CITY OF ALBUQUERQUE

November 29, 2021

Re: US Eagle Credit Union - Academy
5420 Academy Road NE
Traffic Circulation Layout
Engineer's Stamp 11-23-2021 (E18-D046)

Sheet No. **C-101**

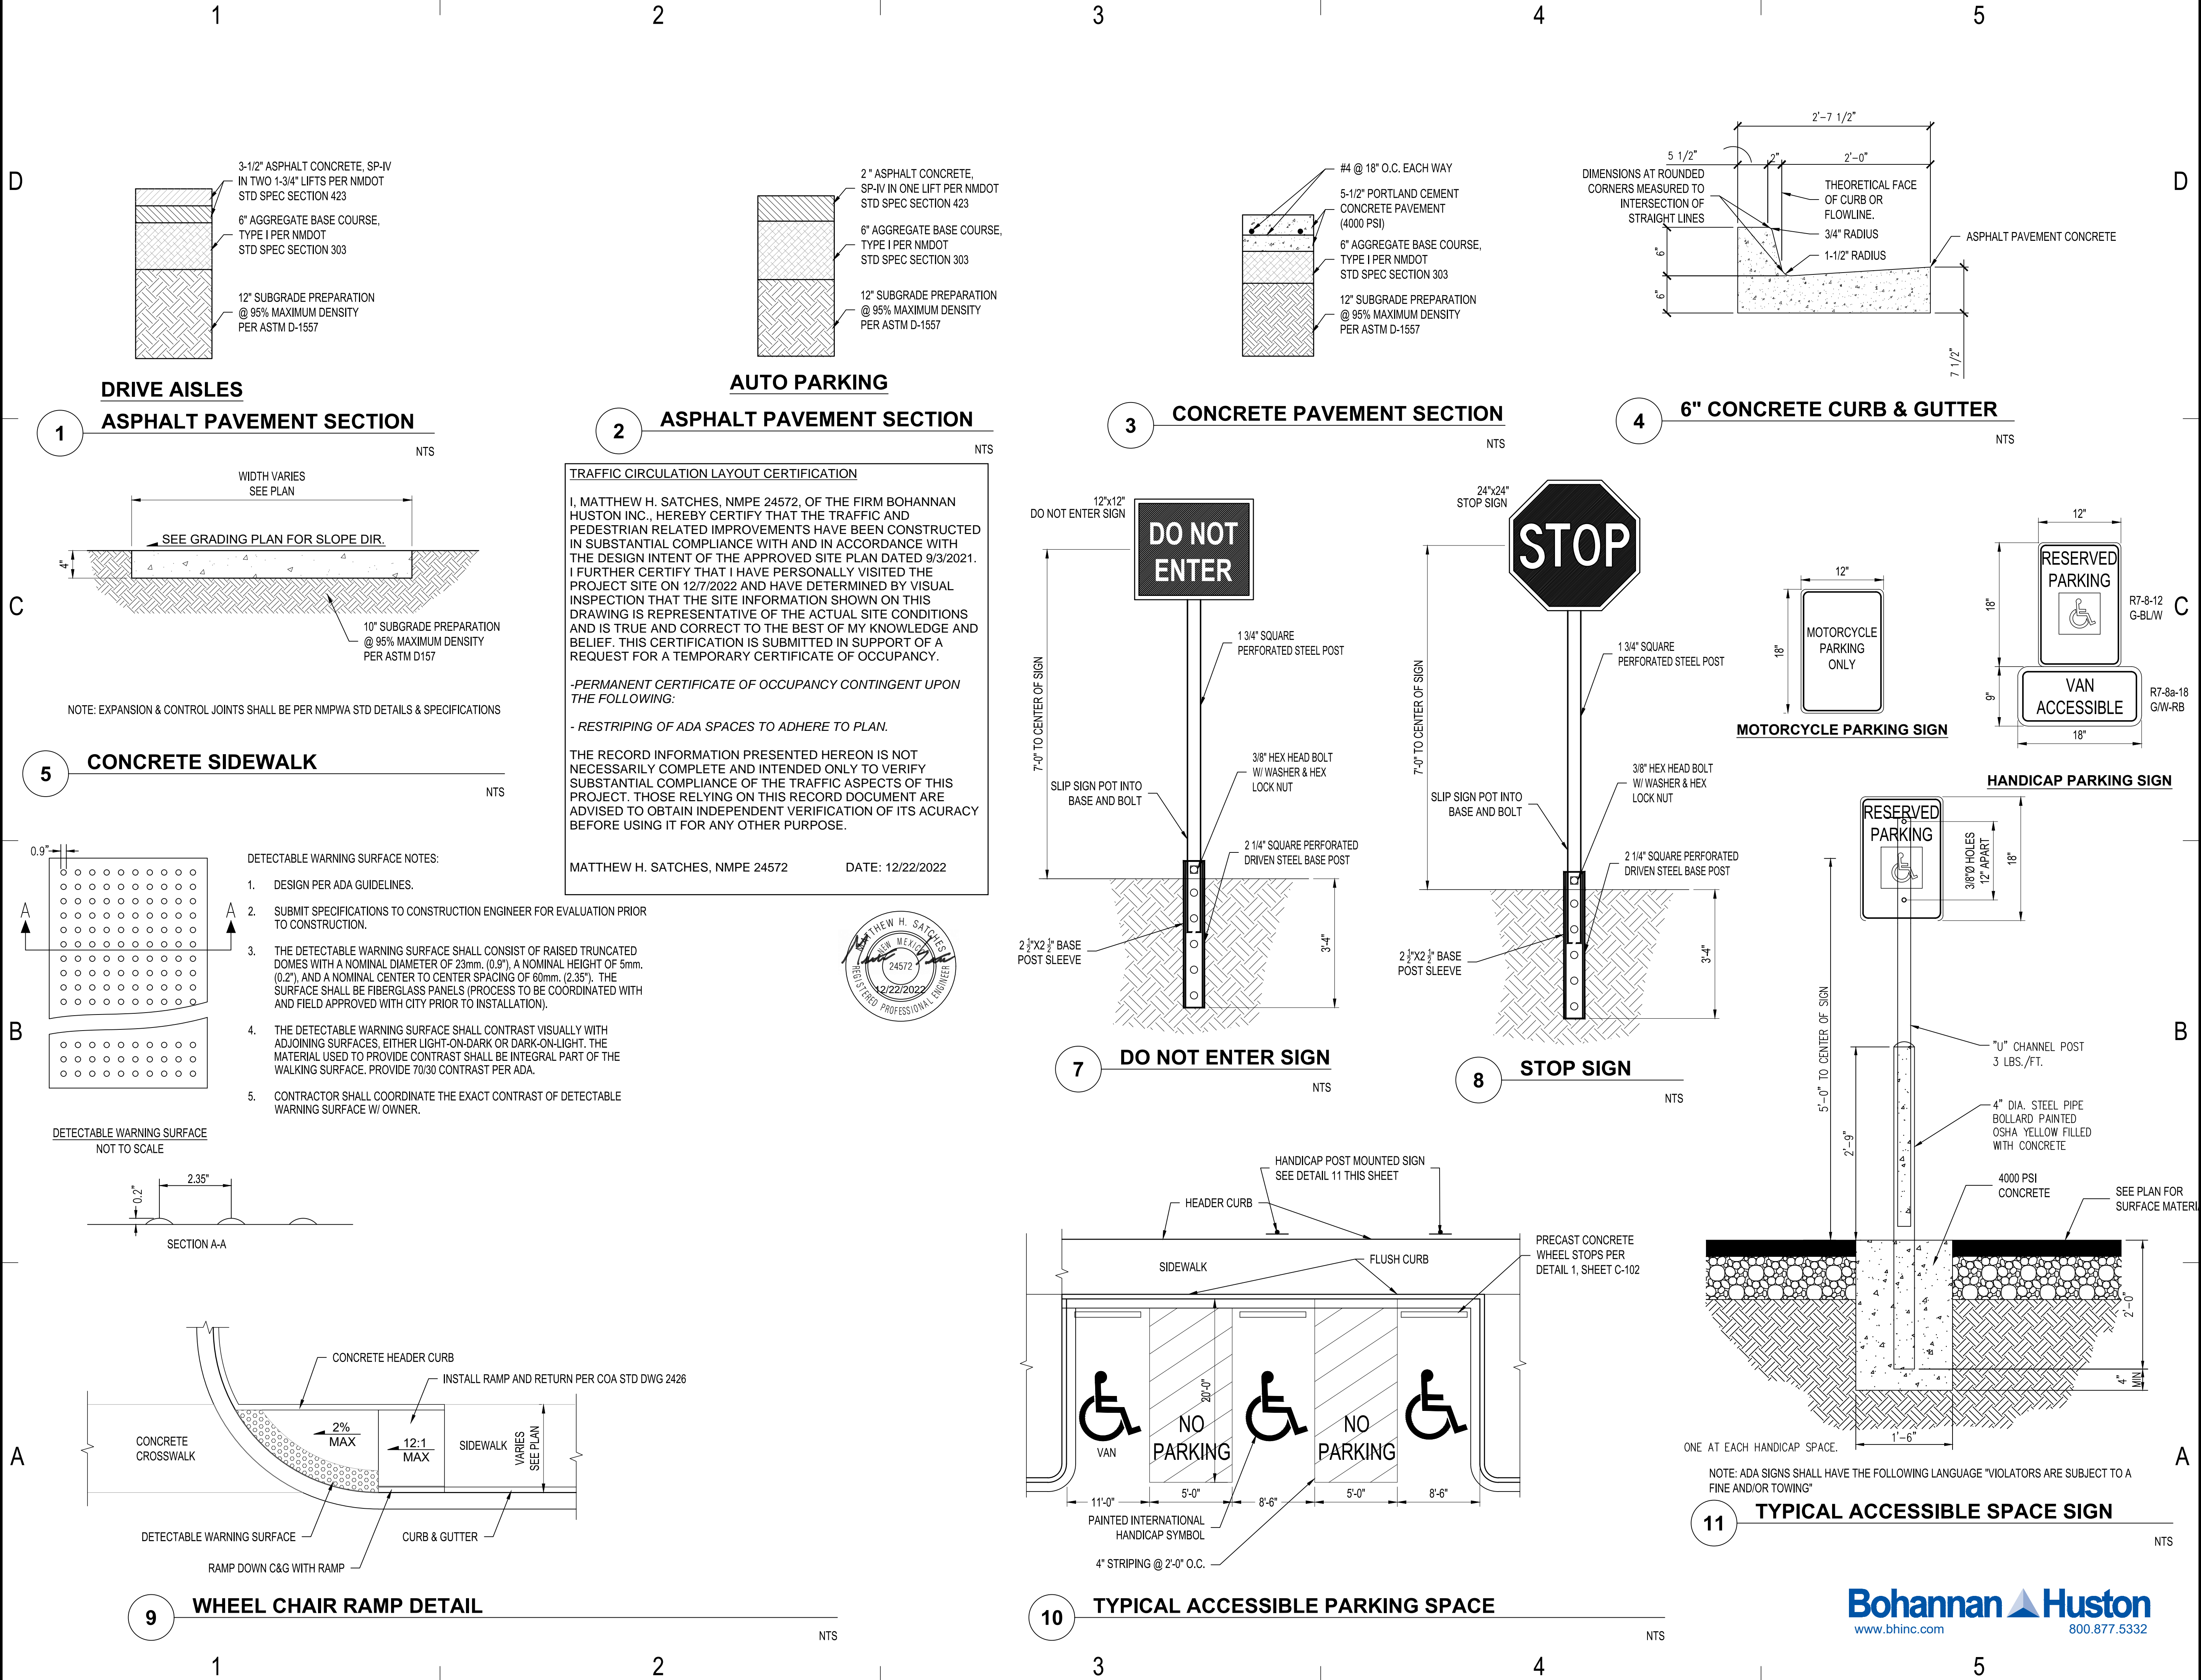
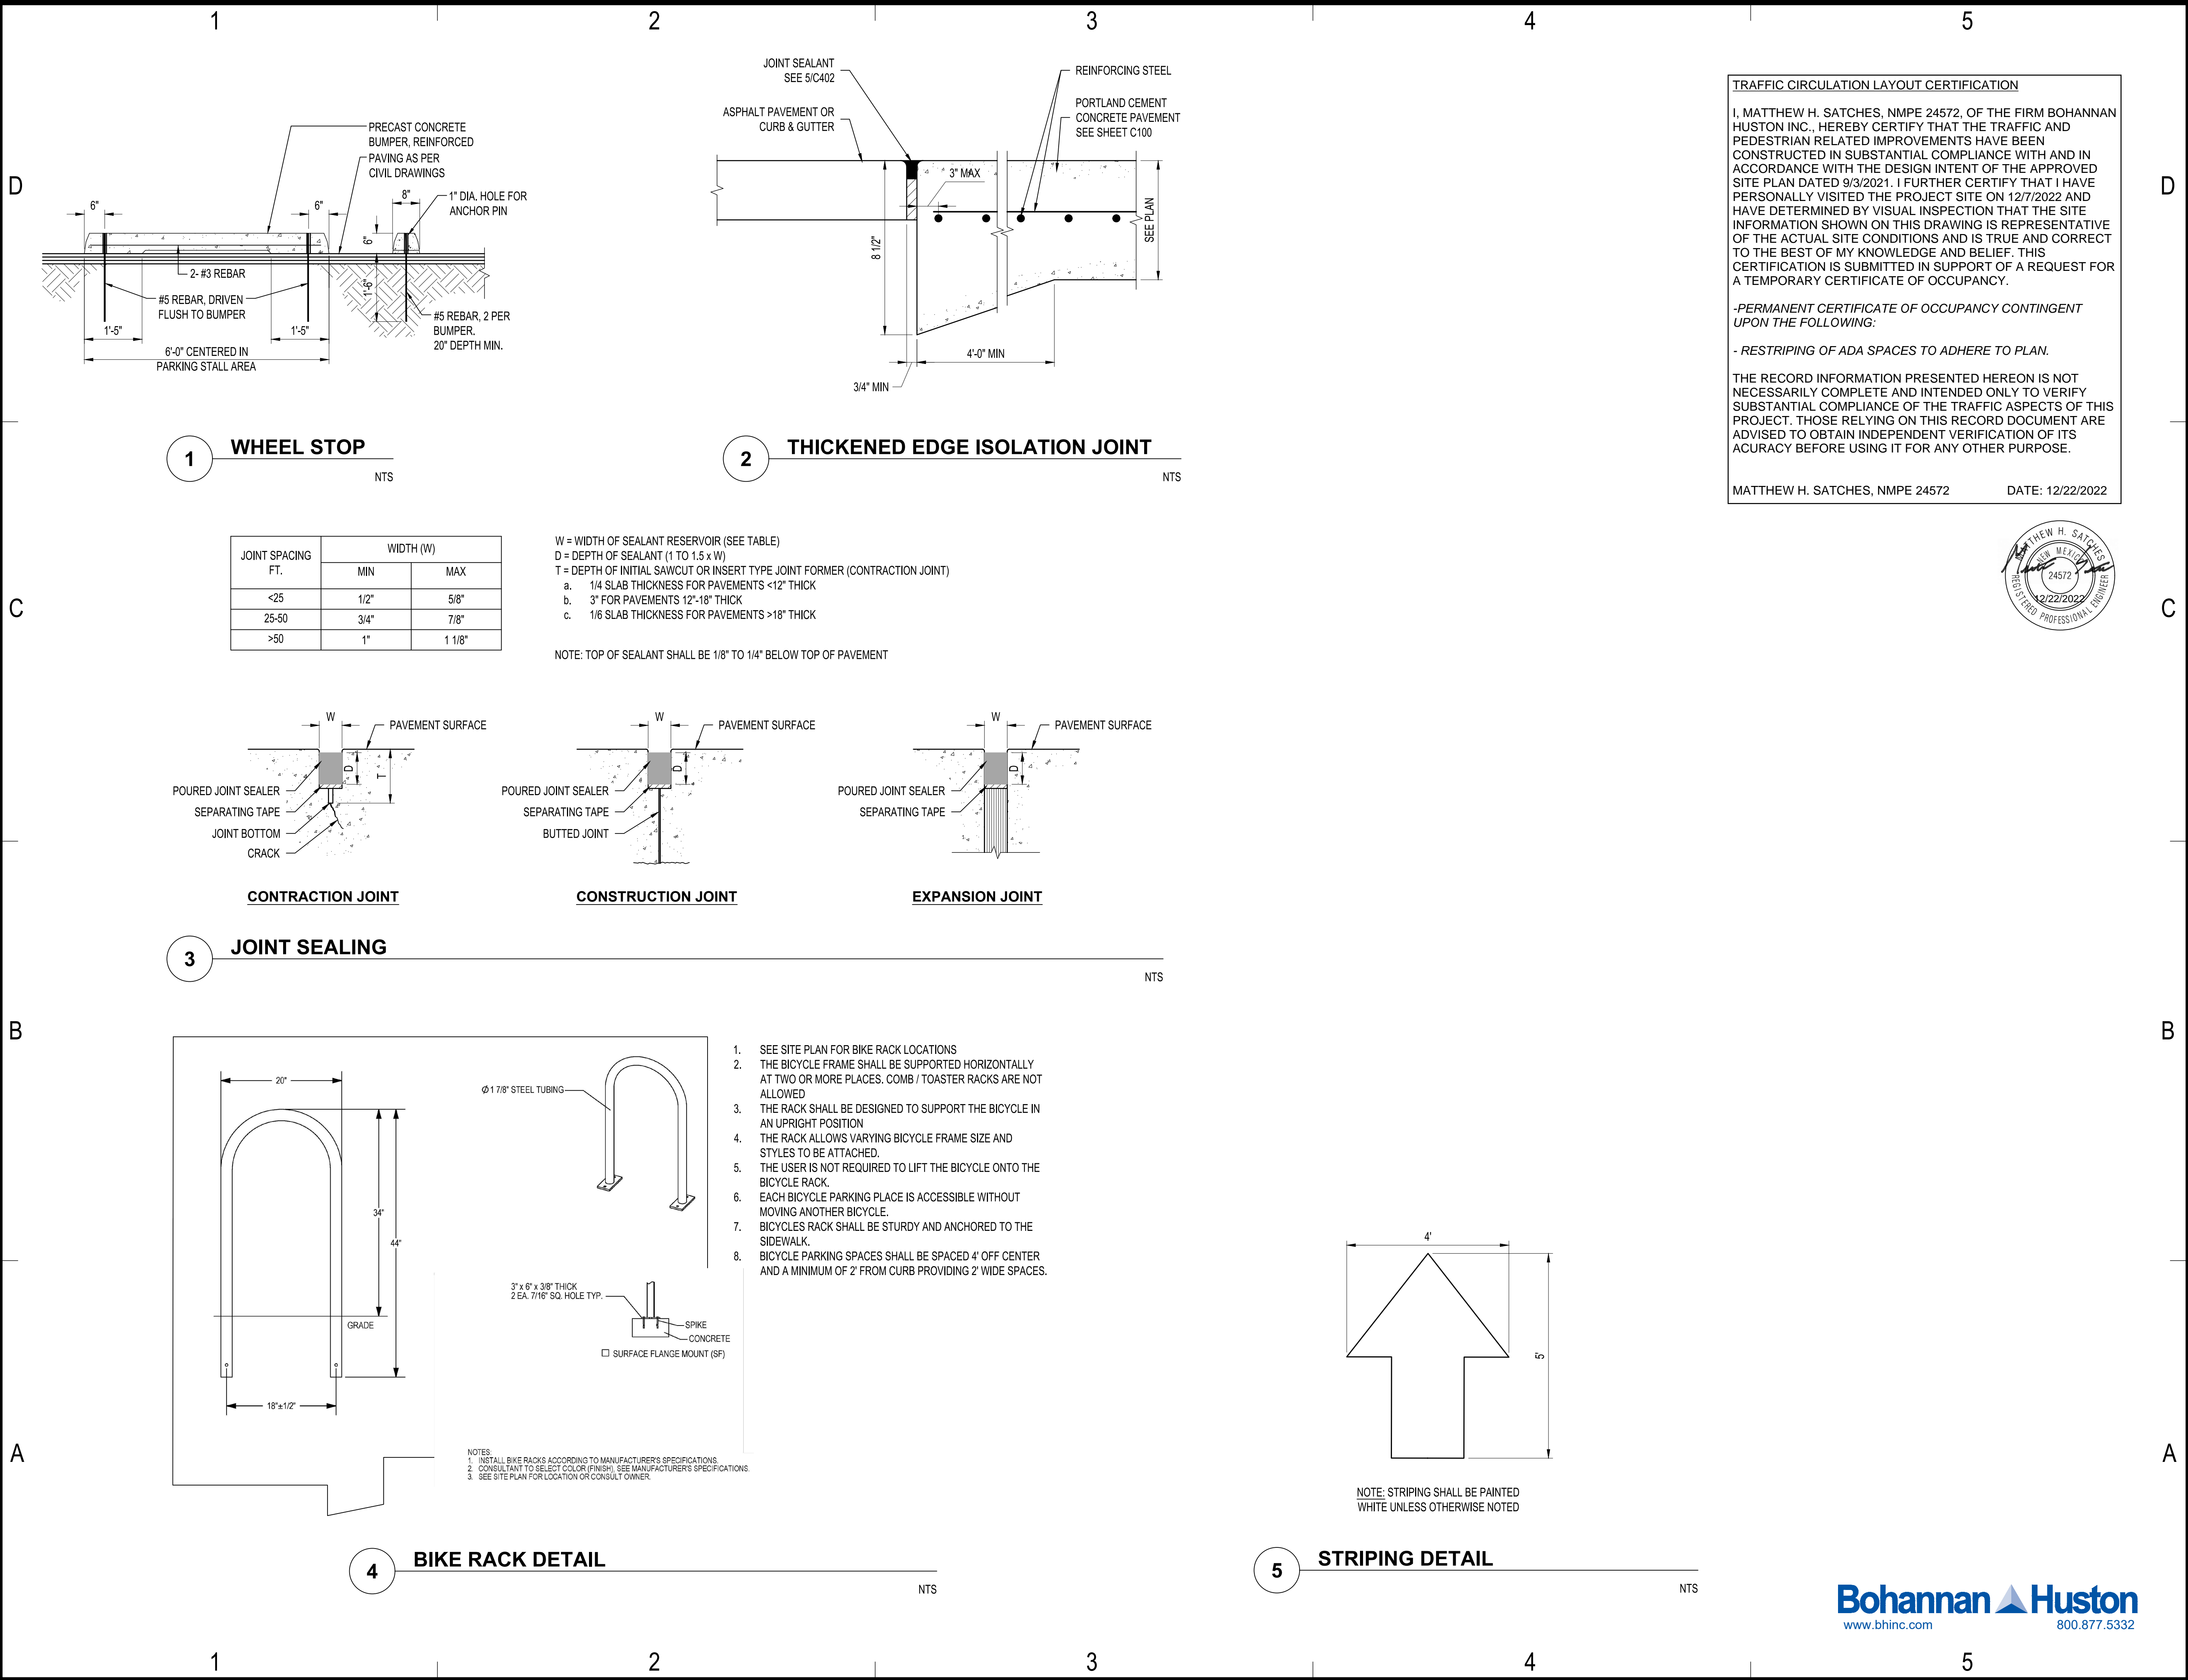
4. The ADA access aisles shall have the words **"NO PARKING"** in capital letters, each of which shall be at least one foot high and at least two inches wide, placed at the rear of the parking space so as to be close to where an adjacent vehicle's rear tire would be placed. (66-1-4.1.B NMSA 1978). **This is shown on Site Plan but it needs to be shown on detail 10, sheet C-101.**
